**From:** [Early, Shane \(DNR\)](#)  
**To:** [Jeremiah Cromie](#)  
**Cc:** [KELLER, ERIC \(DNR\)](#); [MAUNEY, MARTY \(DNR\)](#); [YOUNG, BRENDA \(DNR\)](#)  
**Subject:** RE: SE-21-00017 Clear View - Notice of Application  
**Date:** Thursday, August 26, 2021 10:30:39 AM  
**Attachments:** [image001.png](#)

Thanks for the opportunity to provide comments via the SEPA process for this project (SE-21-00017 Clear View), and note that the project proponent is aware of the future need for a Forest Practices Application (FPA). DNR Southeast Region Forest Practices would like to submit the following comments in regard to this proposal:

**CLEAR VIEW ACRES SHORT PLAT
KITITAS COUNTY SHORT PLAT NO. 06-XX
PTN. OF THE WEST 1/2 OF SEC. 1, T.19N., R.14E., W.M.
KITITAS COUNTY, WASHINGTON**

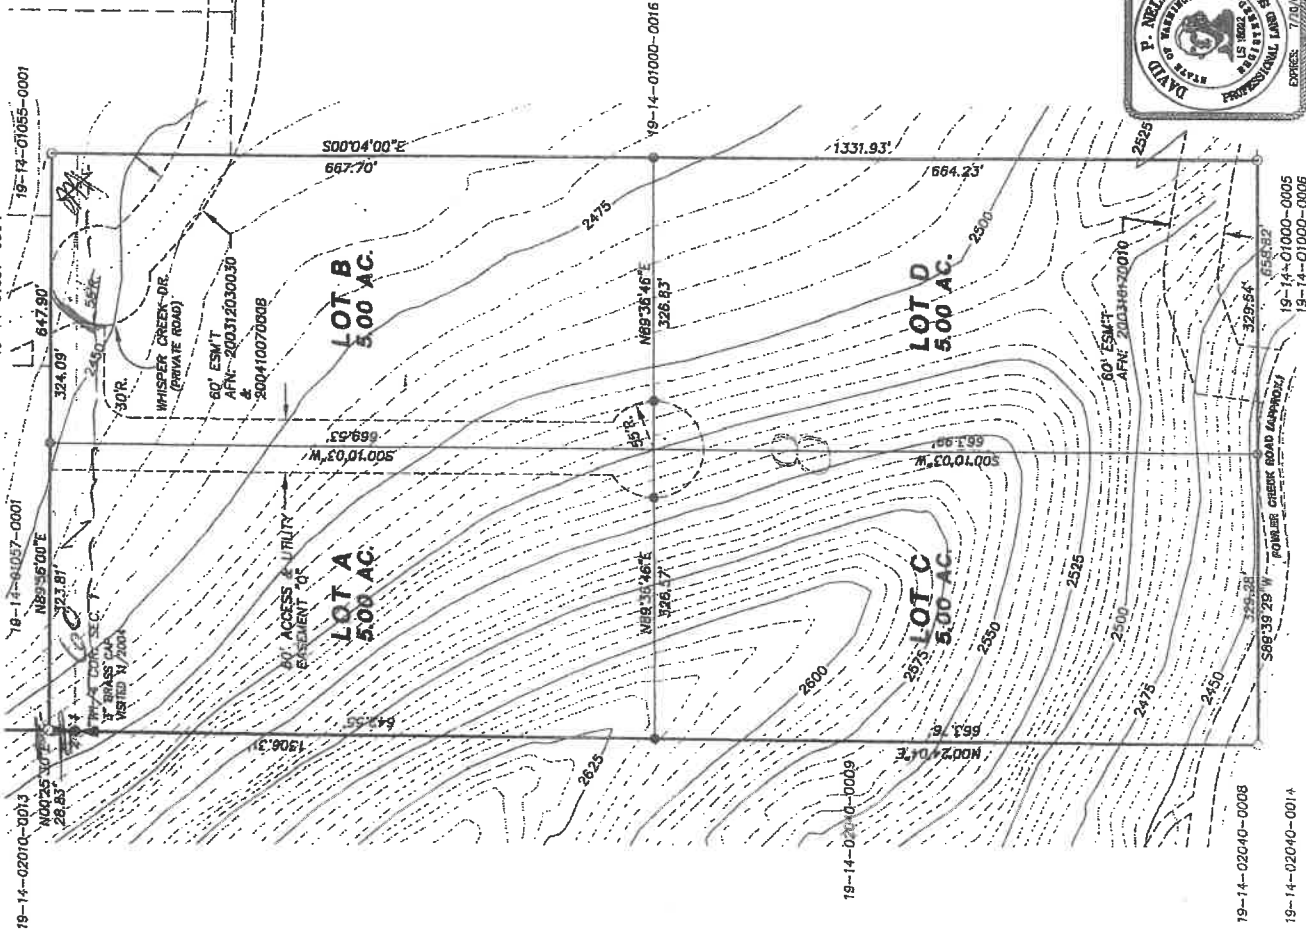
I'd like to comment about the subject Proposal and list some questions. As well as clarify a road issue, as shown on exhibit 2, Clear View Concept Plot Map as envisioned by Encompass, May 2006. This plot layout and its Vicinity Map indicate the property is directly accessed from the North via Stoneridge Drive and then Whisper Creek Drive (both are private, asphalt improved roads) and then is bounded on the south by Fowler Creek Road. However at one point Fowler becomes Pasco Road – which does actually border subject land to the south, via an short, steep hill side. Fowler and Pasco Roads are county roads. Pasco and east half of Fowler Road are low use, dirt, unimproved roads.

We do have concerns about how the included plot designs showing easements along this property and Pasco Road; for what? Utilities? Why?

They also show a 60' and 3' Easement running along east boundary, north to south. Why? Why such an wide easement? Especially when the provided Plot Map as well as current satellite photos shown a rough access road running north to south, right down the middle of subject property, providing perfect easement to the four proposed five acre lots. This initial rough cut road runs from Whisper Creek Road south over about 5/8<sup>th</sup> length of this subject property. Perfect ingress/egress and utility access to these four lots. Especially when the home owner accession (HOA) has allowed Blue Span Communications to install Fiber Optic cable along Stone Ridge Drive and Whisper Creek Drive.

My concern is the odd 63' of easement along east lot line. As well as possible impact on Pasco Road. As long as we can be assured of no vehicle ingress/egress from Whisper Creek Road to Pasco Road; there are no majors issue with this application. To a degree, even an utility easement might be agreeable. Any impact to the steep ridge along south boundary and Pasco Road would be of a concern.
